Application No: EP/124/20/HH
Site Address: Little Dormers 23 Upper Drive East Preston BN16 1QN
Description of works: New bay and porch skirt roof to the front elevation, and roof linked detached double garage.

Thank you for your internet representation made on 16th November 2020 which has been recorded as an objection with the comments as follows:

Location Plan and Block Plan

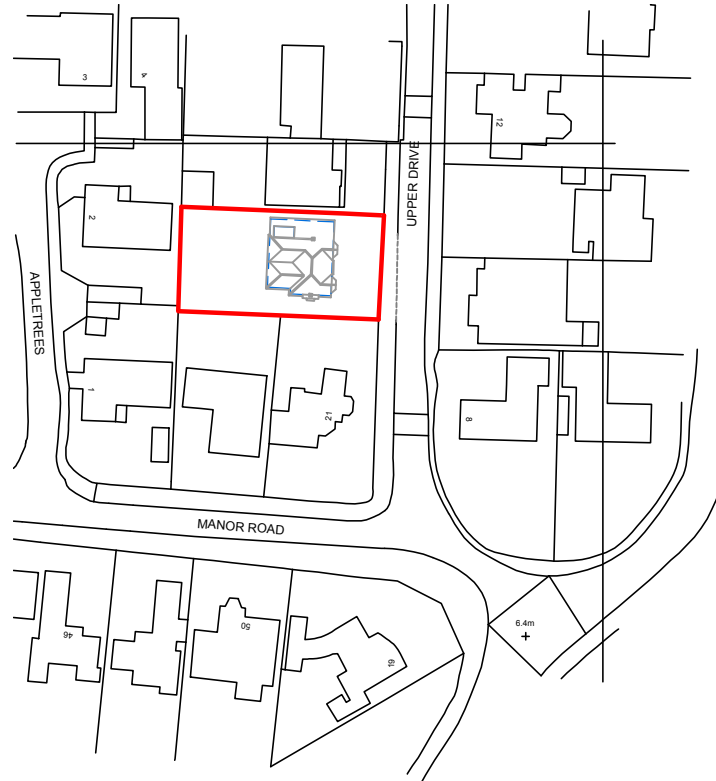
The proposed garage complex is far too large for this site and is in the wrong position.

It would come very close to the road and would look unsightly and out of keeping for the Upper Drive area. No other homes have large structures coming right up to the edge of the road. The proposal to come right up to the boundary of their neighbour, creating a solid barricade will damage the current open look of front gardens and driveways of their neighbour and all the house fronts along this road. It would look so out of place.

Garage Plans and Elevations -
Proposed

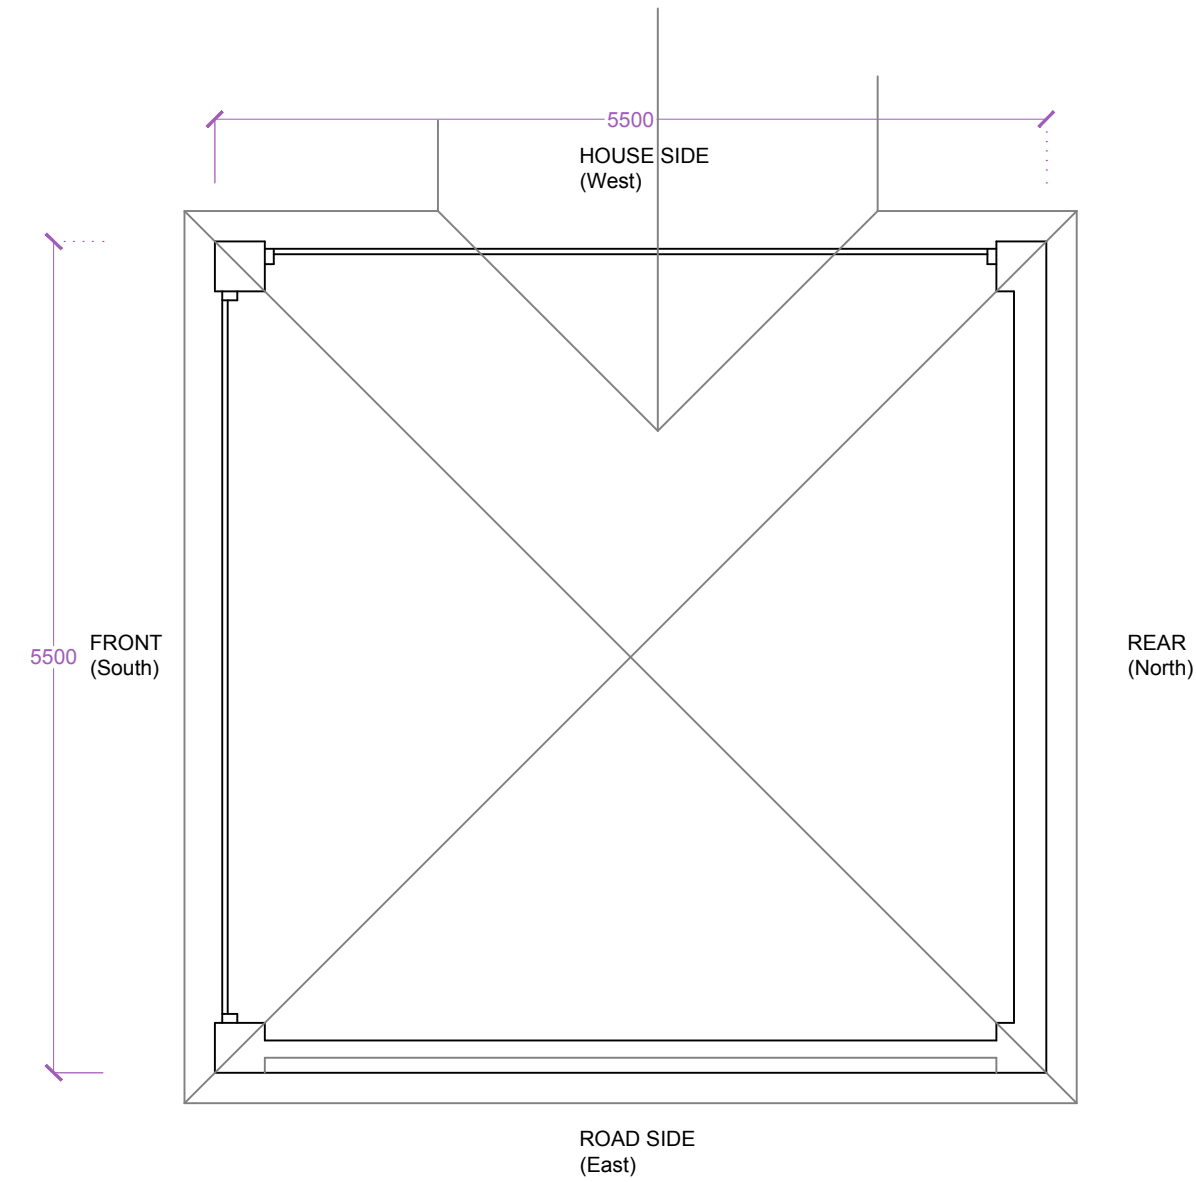
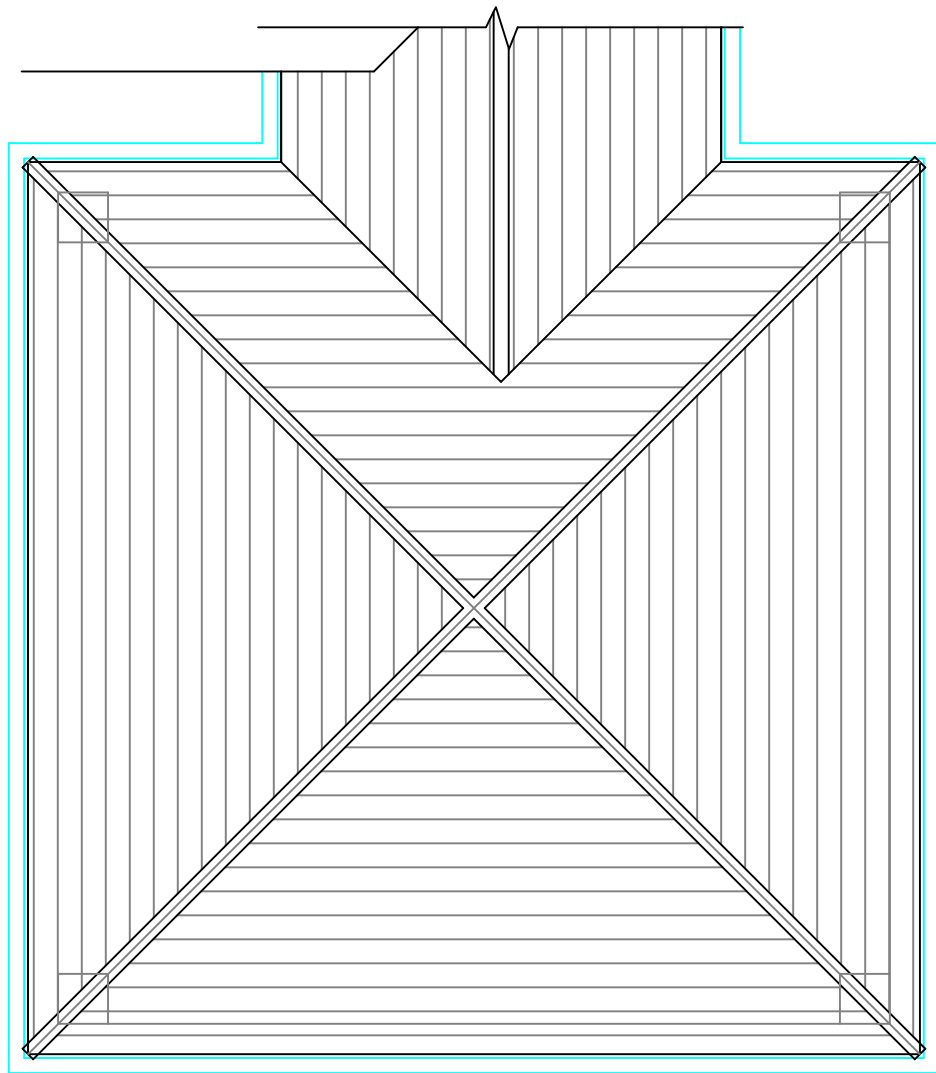
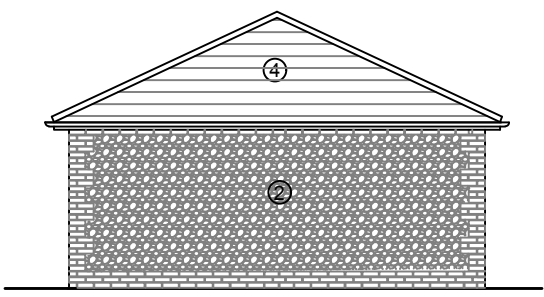
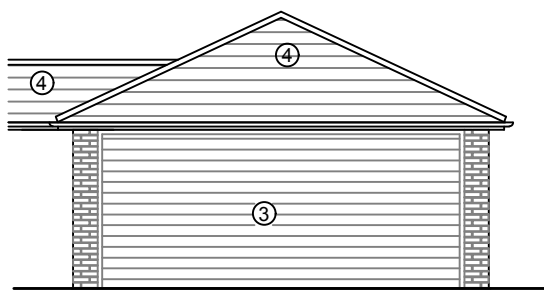
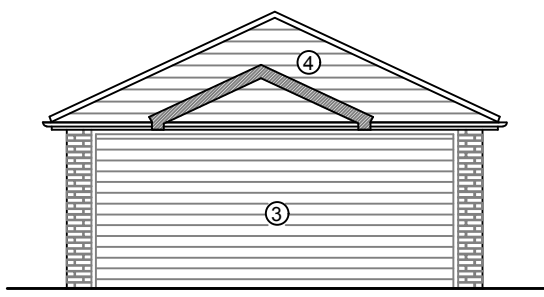
The proposed garage structure would cast a great deal of shadow on to number 25, cutting out all the light to the front of number 25's home and front garden. This will adversely affect their enjoyment of their home and it's sad that the applicant thinks this is an acceptable thing to do.

If the applicant feels that cutting out light to the front of a person's home is acceptable, a far smaller garage, set back from the road, could be placed to the south side of the applicant's drive so that the shadow would be cast over the front of the applicant's own house, and not a neighbour's. This would also be a better location to provide access for the applicant to their back garden where there is now a large access space after they cut all the mature trees and hedging down in the summer.
